Vincentia Market Place- Modification 3 to MP06 0025

Response to Submissions- Drawing Revisions

CIVILWORKS
GENERAL ARRANGEMENT
KEYPLAN

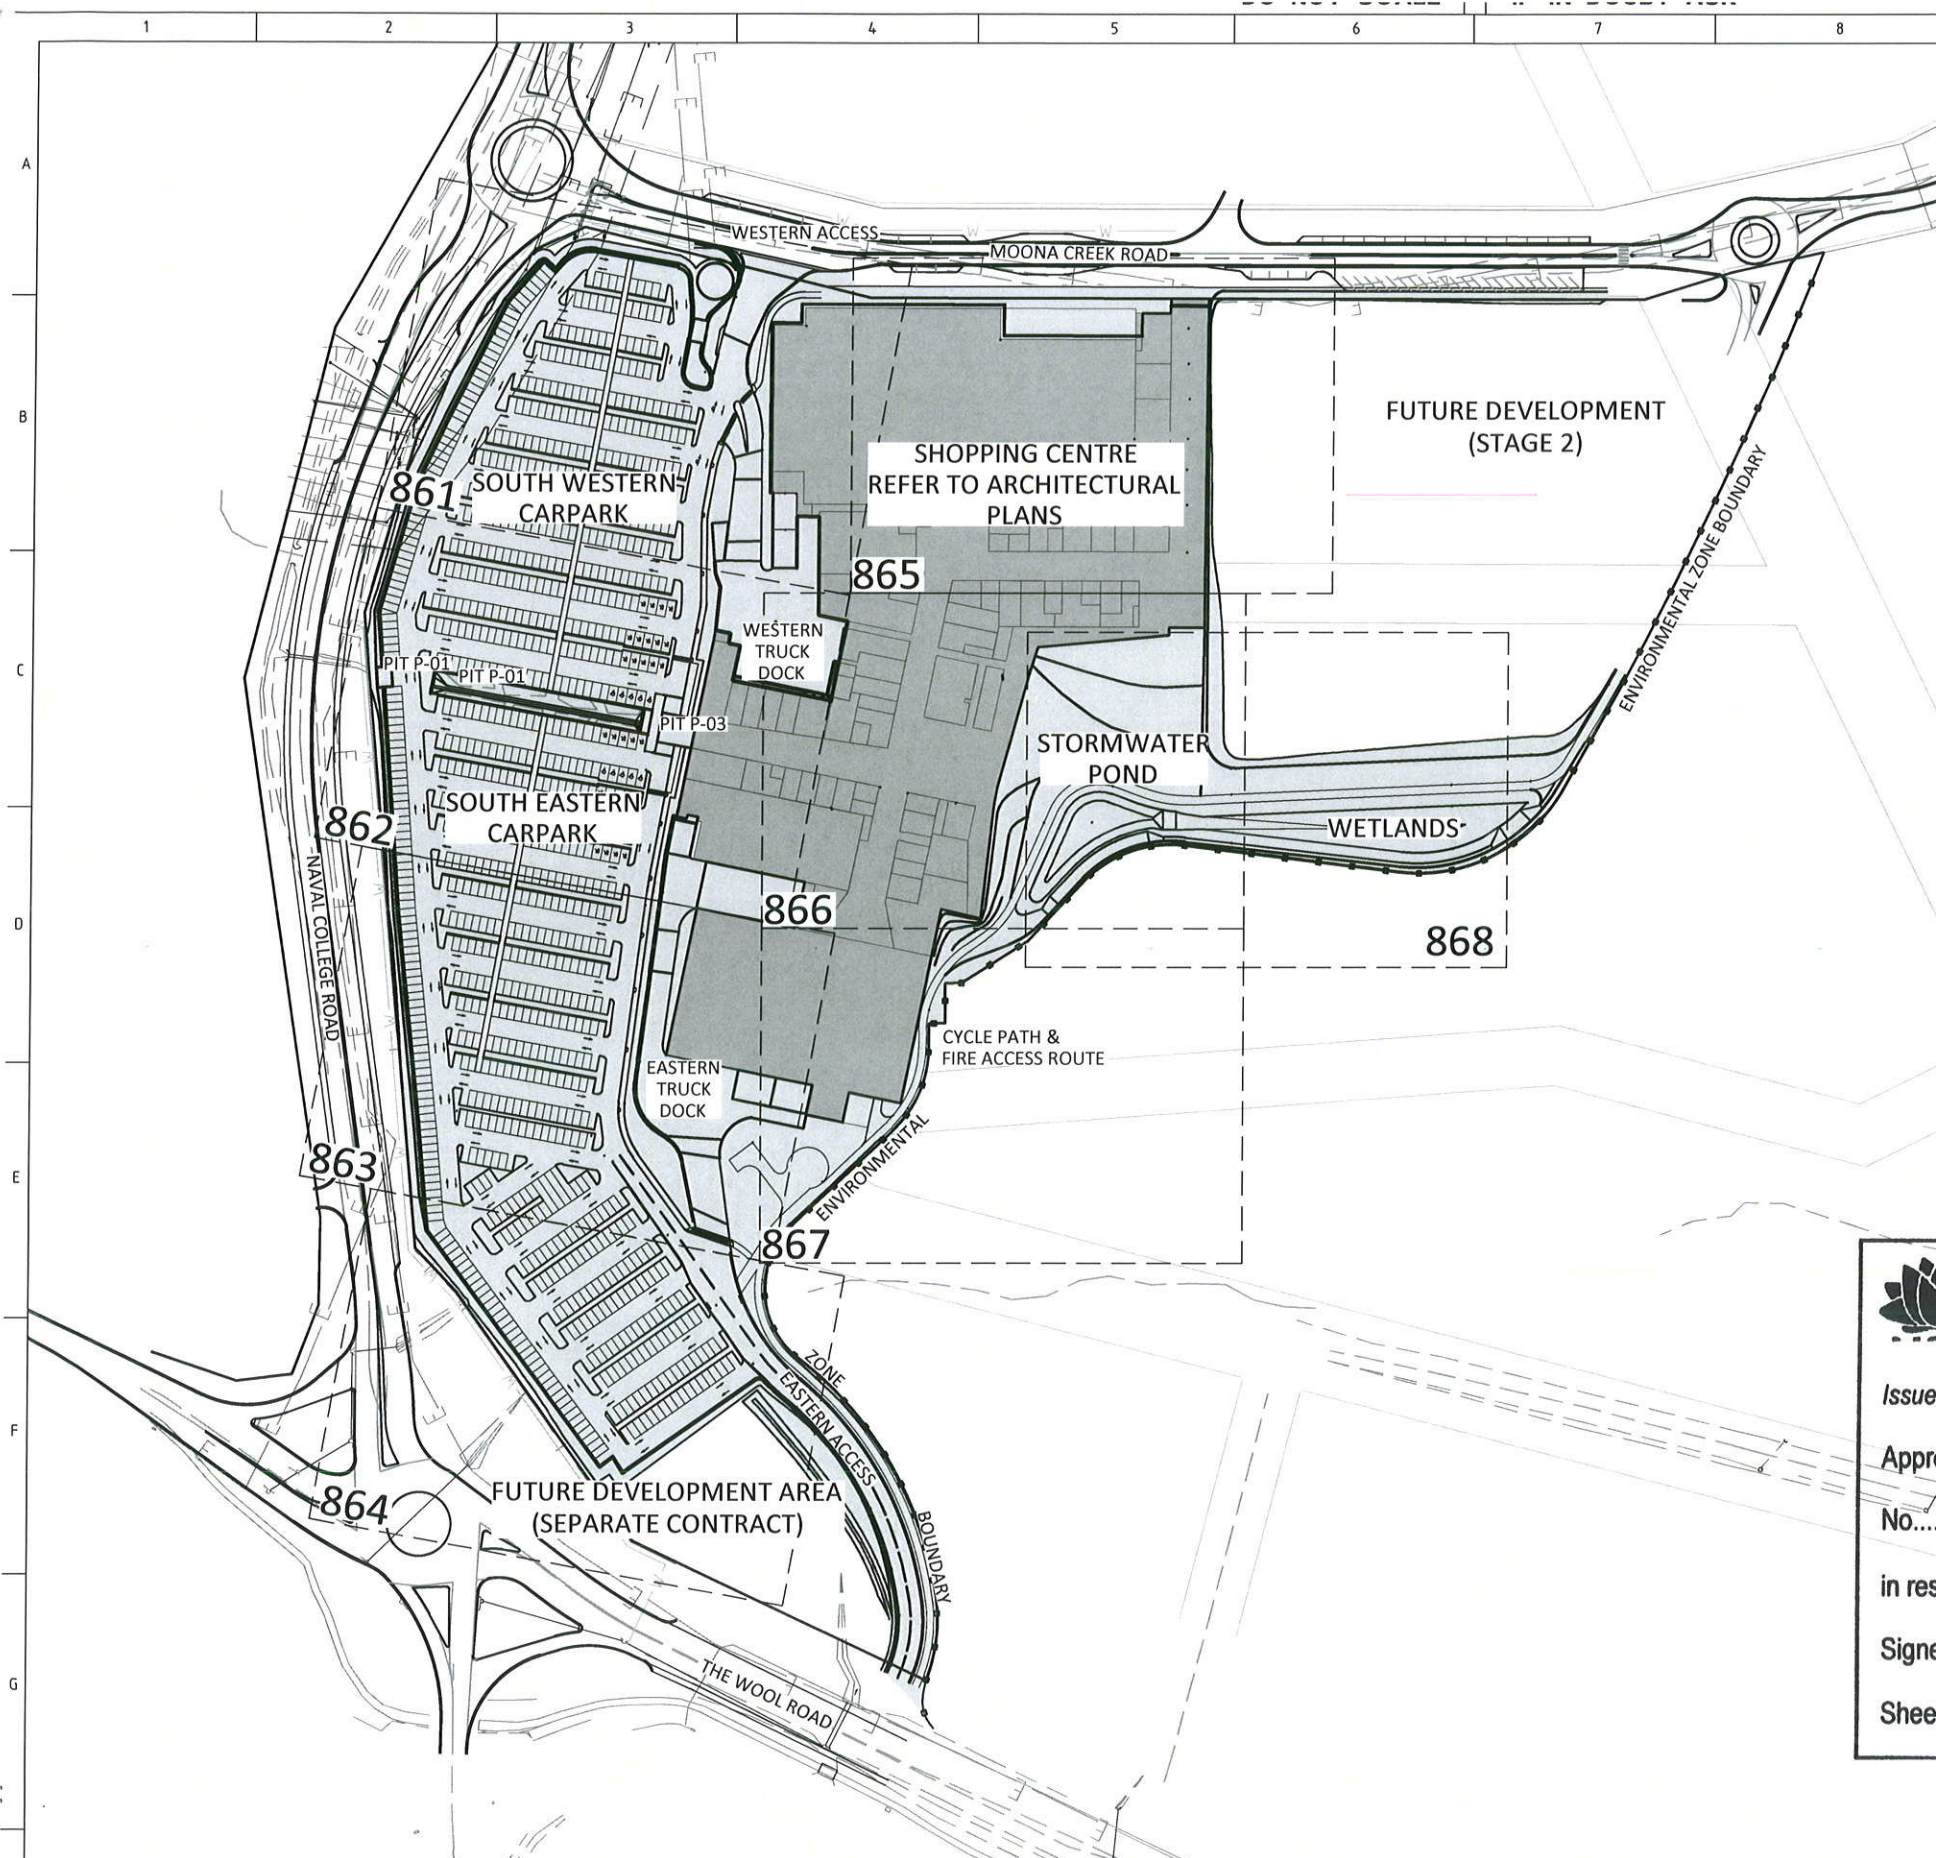
Dwg	Type	Drawing	Date	Rev.
46860	CIVILWORKS	GENERAL ARRANGEMENT	5.07.2011	P1
46861	CIVILWORKS	ROADING & DRAINAGE	5.07.2011	P1
46863	CIVILWORKS	ROADING & DRAINAGE	5.07.2011	P1
46864	CIVILWORKS	ROADING & DRAINAGE	5.07.2011	P1
46865	CIVILWORKS	ROADING & DRAINAGE	5.07.2011	P1
46870	CIVILWORKS	KERBS & RETAINING	5.07.2011	P1
46871	CIVILWORKS	PAVEMENT TYPES	5.07.2011	P1
46893	CIVILWORKS	CLEARING	5.07.2011	P1
